Item No. **Report of the Head of Development Management and Building Control**

Address: 48 MYRTLE AVENUE RUISLIP

Development: Conversion of roof space to habitable use including raising the ridge height and alterations to roof profile with 2 x rear dormers, 3 x front roof lights (revised description)

LBH Ref Nos: 77167/APP/2023/2854

PROPOSED LOFT PLAN

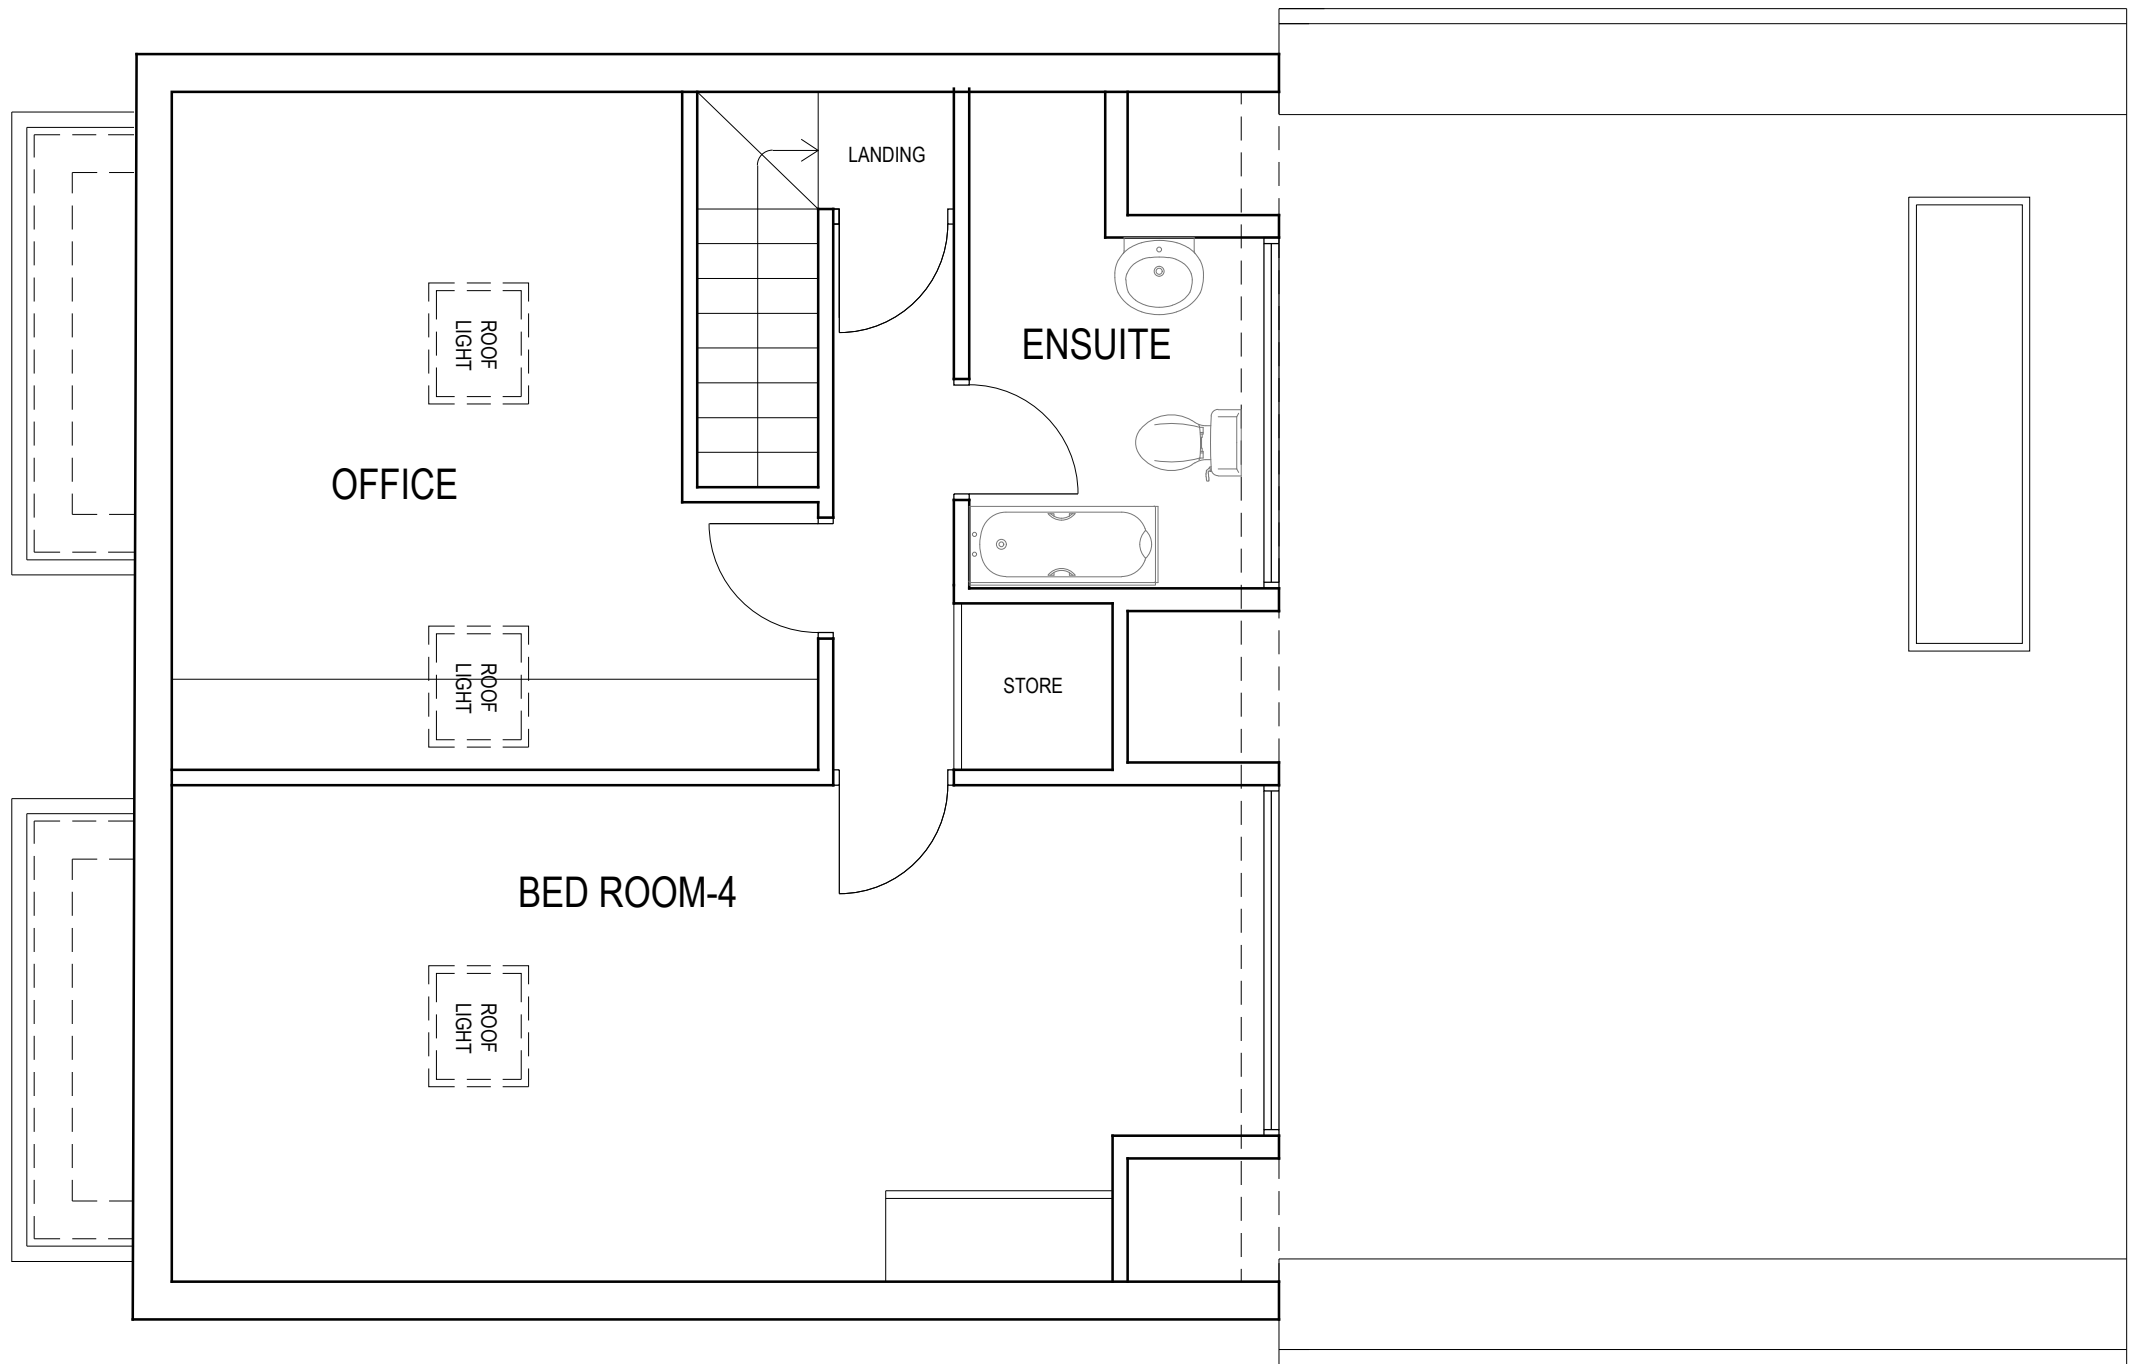
The application is proposing a conversion of roof space to habitable use including raising the ridge height and alterations to roof profile with 2 x rear dormers and 3 x front roof lights. The proposed roof extension would create a new storey to the main dwelling with two new habitable rooms on the new first floor. The new roof form would be a mansard style with gable ends. The roof increase in height from the eaves would be approximately 1.33m.

PROPOSED FRONT ELEVATION

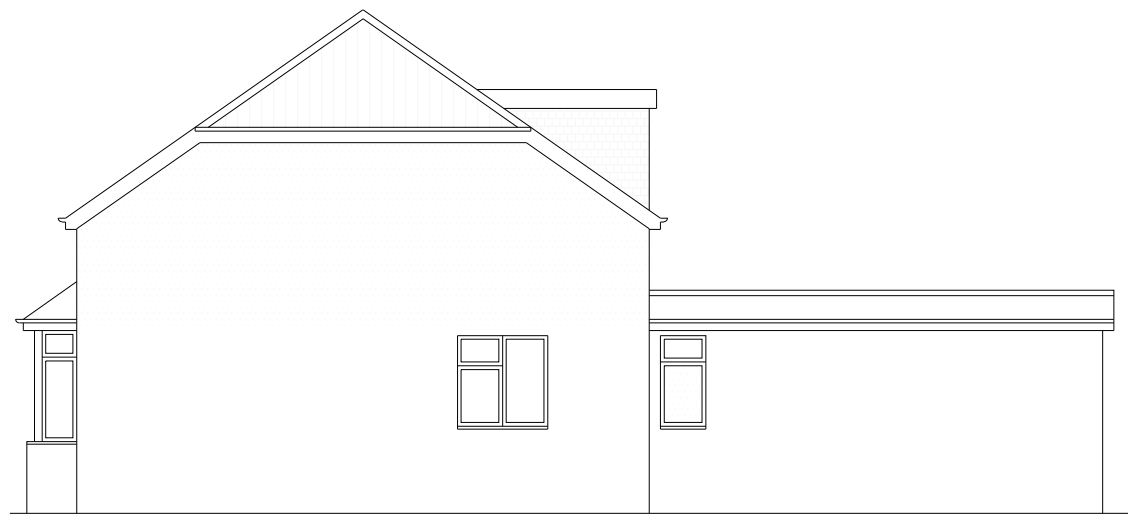
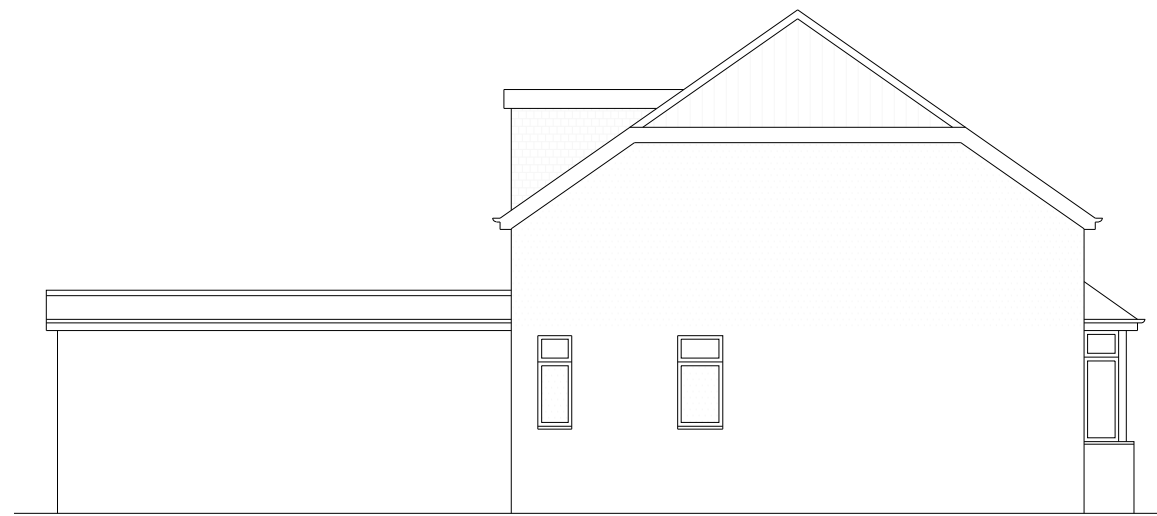
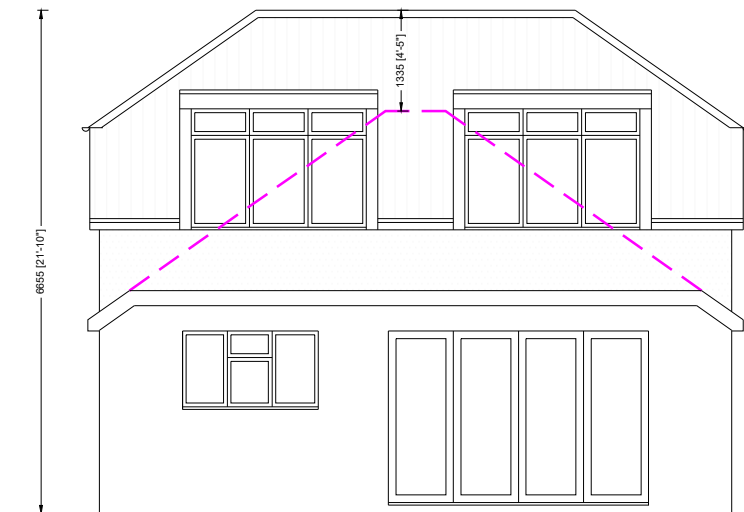
The design of the proposal aims to mimic what is existing across the road at No. 45 Myrtle Avenue. However, it should be noted that the two properties are markedly different and the development at No. 45 is not considered to justify the proposed development. The site at No. 45 is set back approximately 9m from the highway as well as being set well in from both its neighbouring properties (12m from the western boundary), whereas, the application property is sited close to the site boundaries and would have a more prominent impact on the street scene and the neighbouring buildings.

In addition, No.45 is sited in between a two storey dwelling to the east and a bungalow to the west and acts as a transition in height. In comparison, the application site is located in the middle of two bungalows which are of a similar height to the existing dwelling. As a result, the proposed increase in height and alterations to the roof profile would be incongruous.

The proposed rear dormers windows are not subservient and do not respect the window hierarchy of the dwelling, creating a top heavy and poorly designed proposal which would substantially alter the appearance of the property, visible from multiple public and private view points.

Moreover, the roof alterations, when viewed as a whole, would appear out of character with the surrounding area, where the vast majority of bungalow properties have retained their hipped roof forms, some with a distinctive gable feature to the front. It is noted that no other property has been extended in such a manner, and the proposed mansard roof and eaves height would compete with and detract from the existing modest roof profile. In this context, it is considered that the roof form would result in an incongruous and insubordinate development that fails to respect the character of the area. Therefore, the significant increase in the overall size, prominence, scale, bulk and massing of the host dwelling would result in a development that would not appear subordinate and out of character.

Therefore, it is considered that the proposed development, when viewed as a whole, would be completely disproportionate, overly prominent and unsympathetic to the original architectural composition of the host dwelling, resulting in the proposed development having a harmful impact to original dwelling, and the character, appearance and visual amenities of the area. The proposal would therefore conflict with Paragraphs 130b) and 134 of the National Planning Policy Framework (2021), Policies D3 and D4 of the London Plan (2021), Policy BE1 of the Hillingdon Local Plan: Part One Strategic Policies (2012) and Policies DMHB 11, DMHB 12 and DMHD 1 of the Hillingdon Local Plan: Part Two - Development Management Policies (2020).
